TII26-136323

RE: An Coimisiún Pleanála - Case reference: VA04.324274, Coom Green Energy Park Grid Connection Planning Application.

Transport Infrastructure Ireland (TII) acknowledges receipt of referral of the above proposed roposed CGEP 110kV substation and grid connection at **Coom Green Energy Park**

SHEET TITLE
M8 HDD Undercrossing Detail

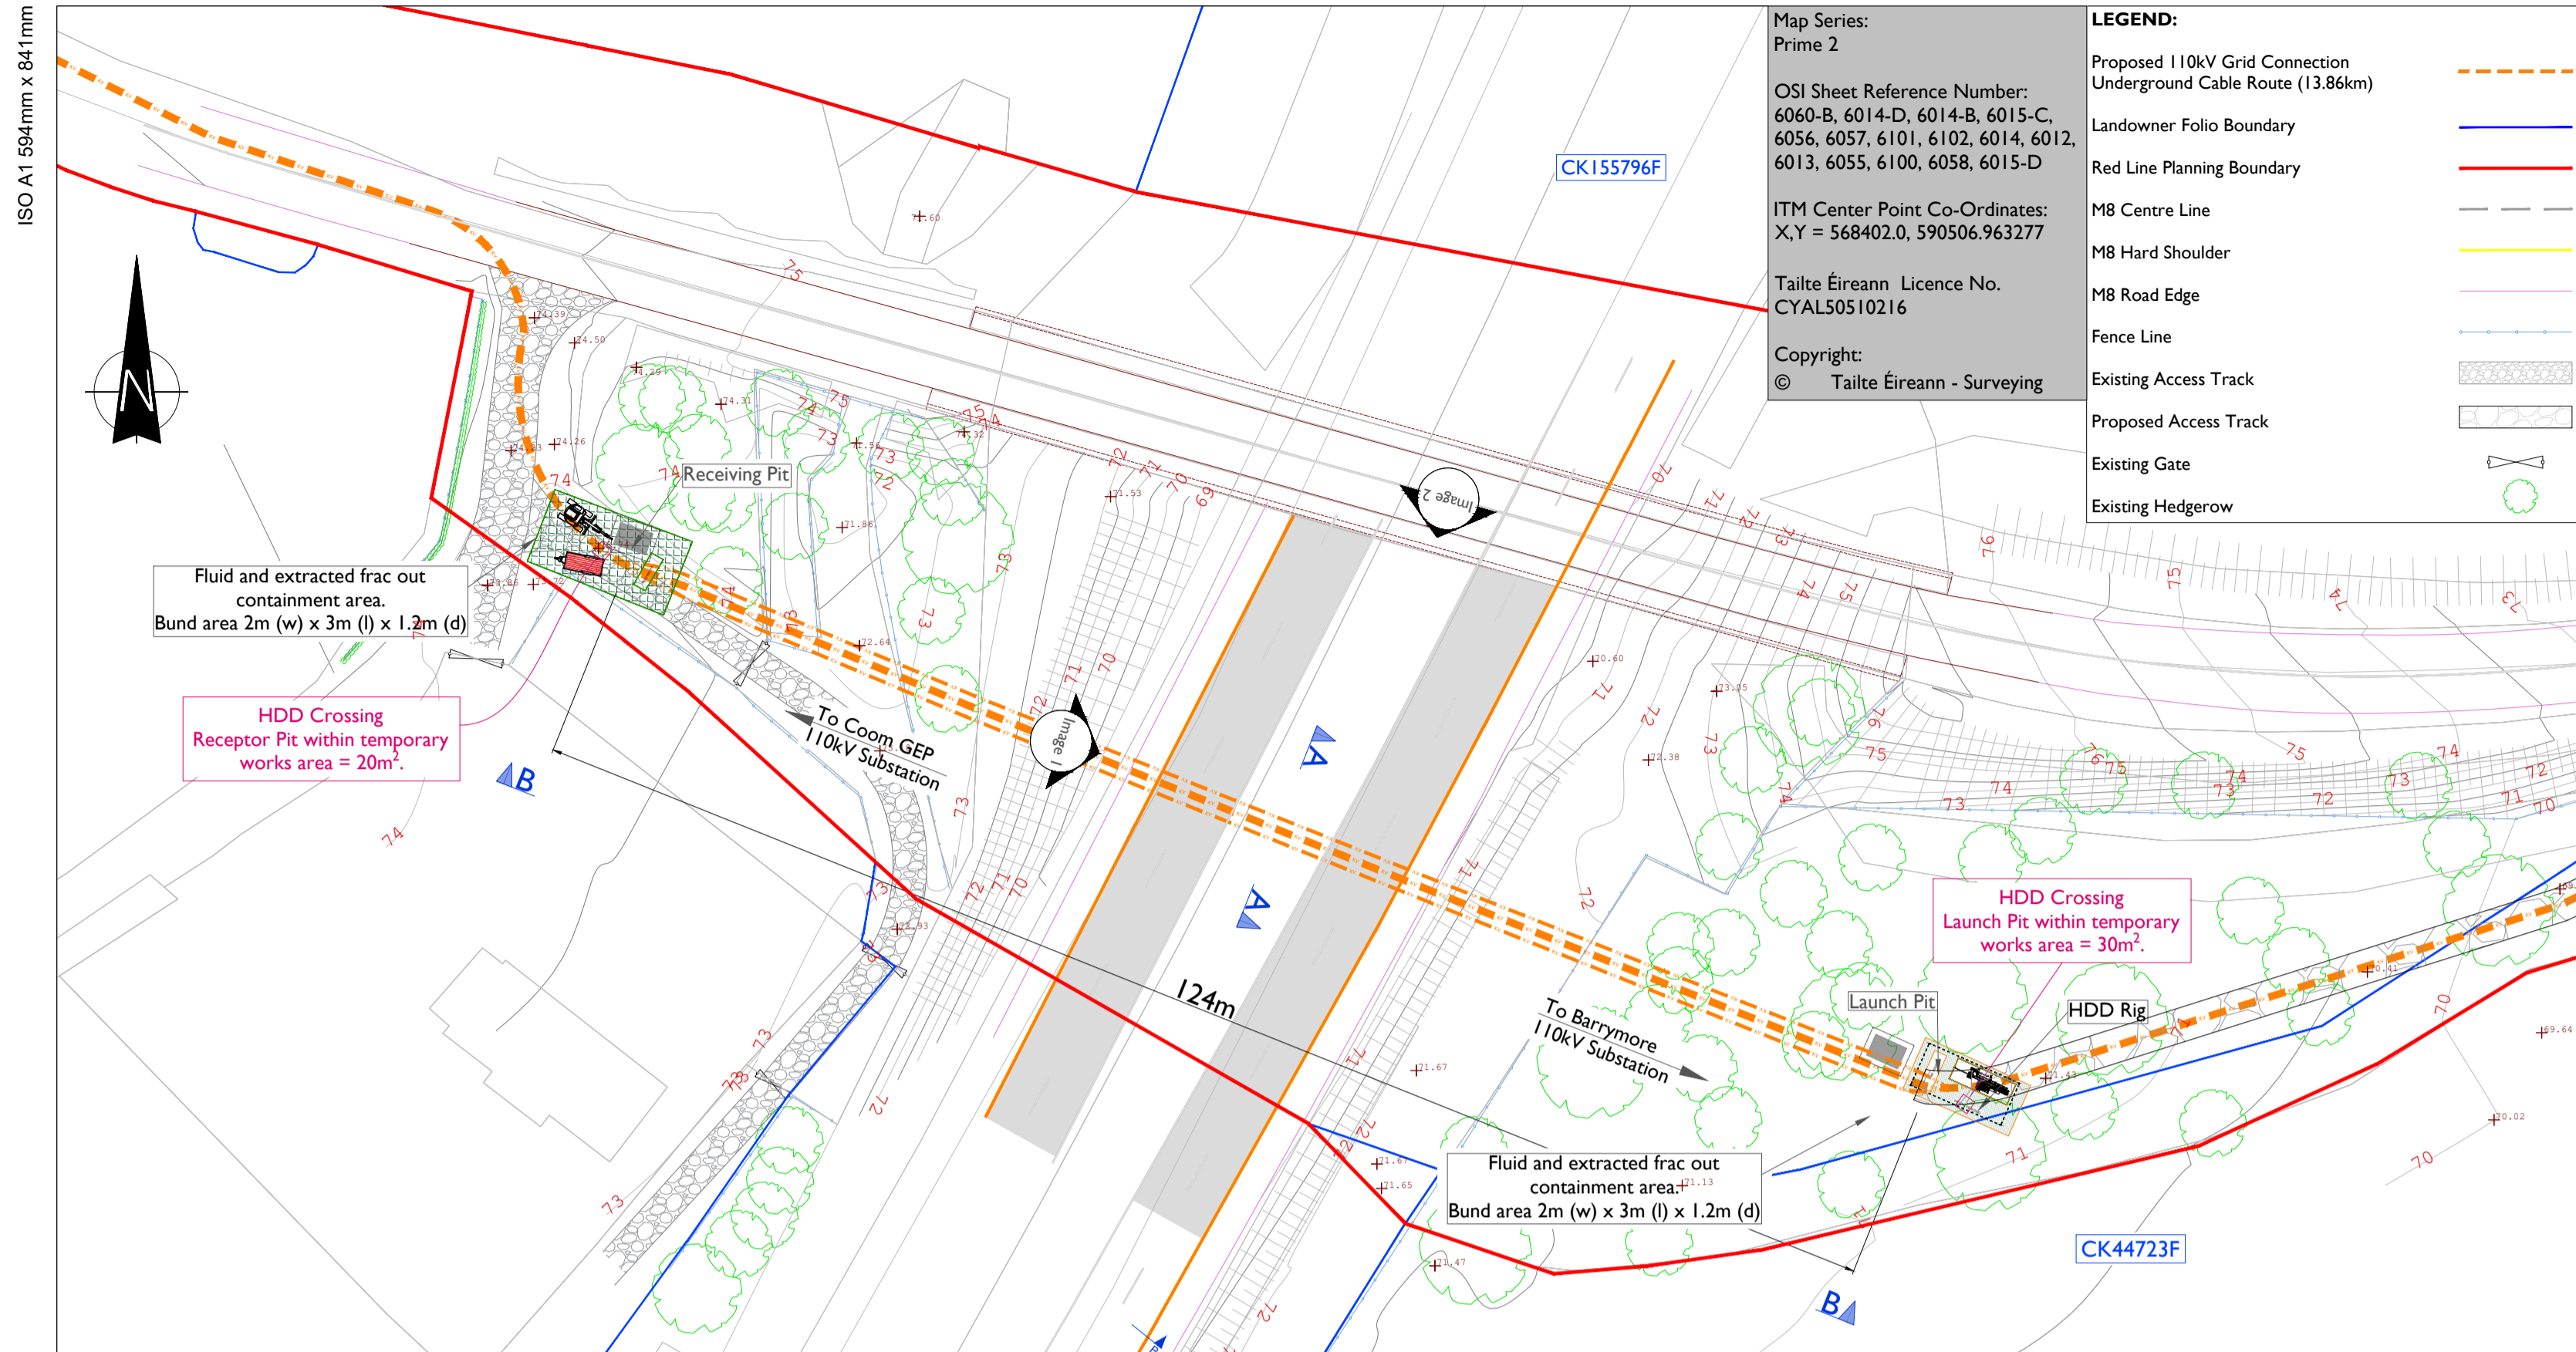
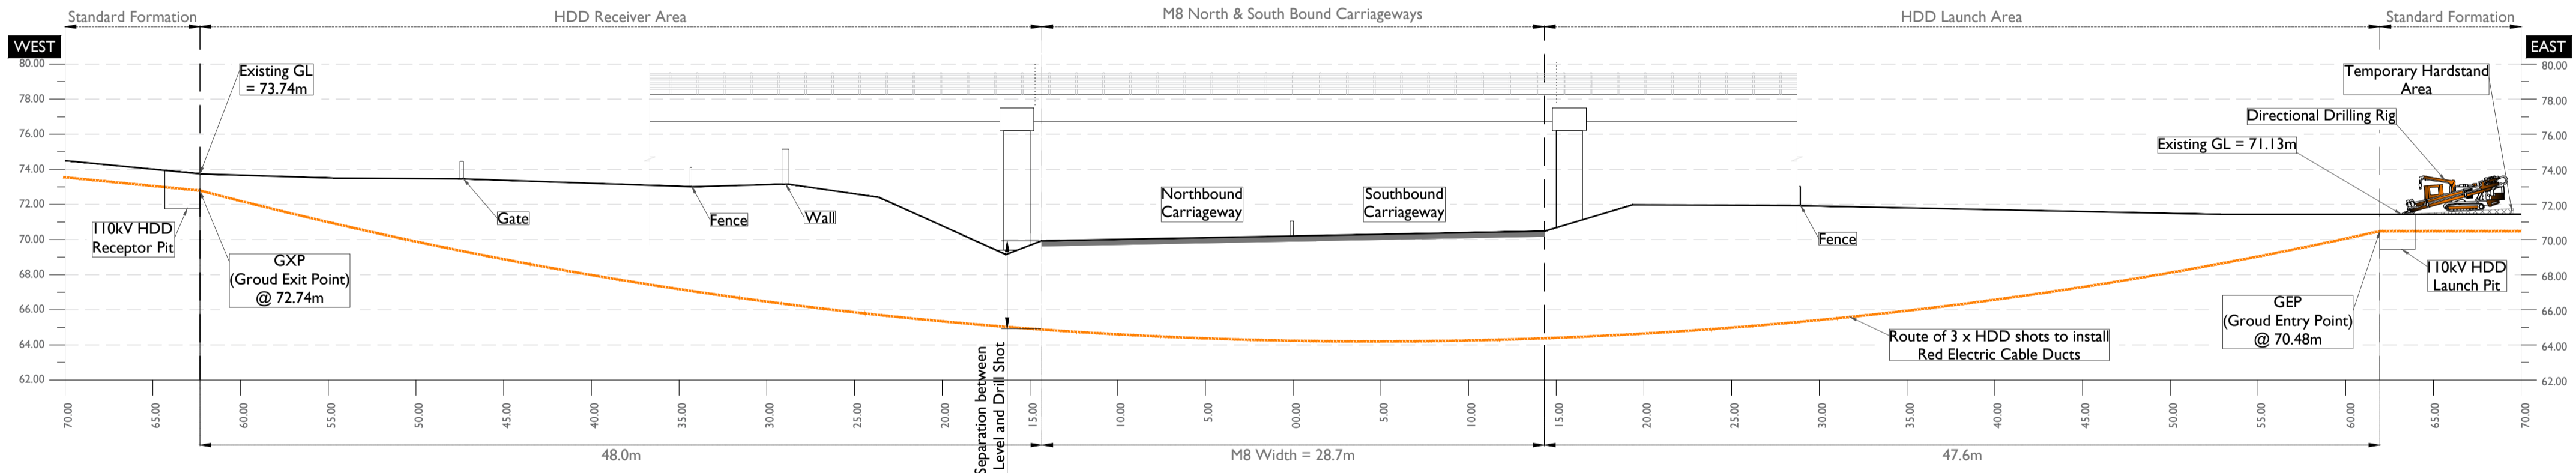
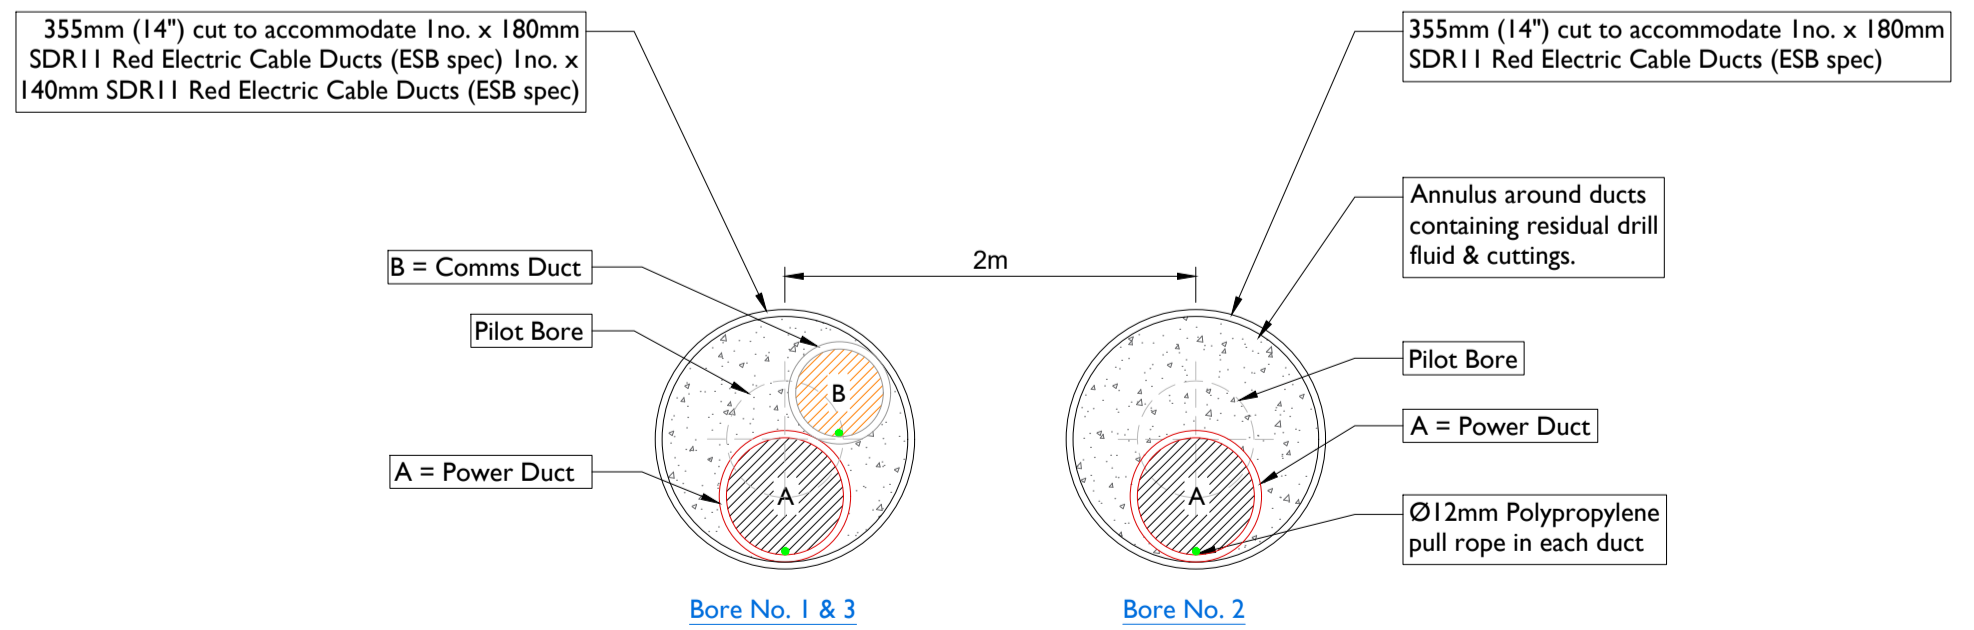
❖ **Requirements for HDD Crossing of the M8 Motorway Network**

- The launch and reception pits for the crossing are located outside the Motorway boundary,
- The cabling/pipeline will be installed at such depth so as not to conflict with the drainage for the Motorway,
- Neither the Works nor the cable crossing will damage or interfere with the Motorway,
- Any maintenance and/or future planned upgrades of the cabling/pipeline at the crossing location can be carried out without access to the motorway boundary,

- There are no bolted joints in that part of the crossing within the motorway fence-line,
- A pre and post construction survey shall be required along the length of the crossing over the extents of the motorway boundary,
- Specific requirements may also arise for these proposed works.

Further liaison with TII “Third Party Works” will be required as drawings made available do not have sufficient detail for inclusion in TII consent requirements for example PPP boundaries and the entry and exit point of each bore must be clearly marked along with junction 5 labelled)

1. *This permission does not approve nor imply consent for any works within the M8, Motorway Reservations.*
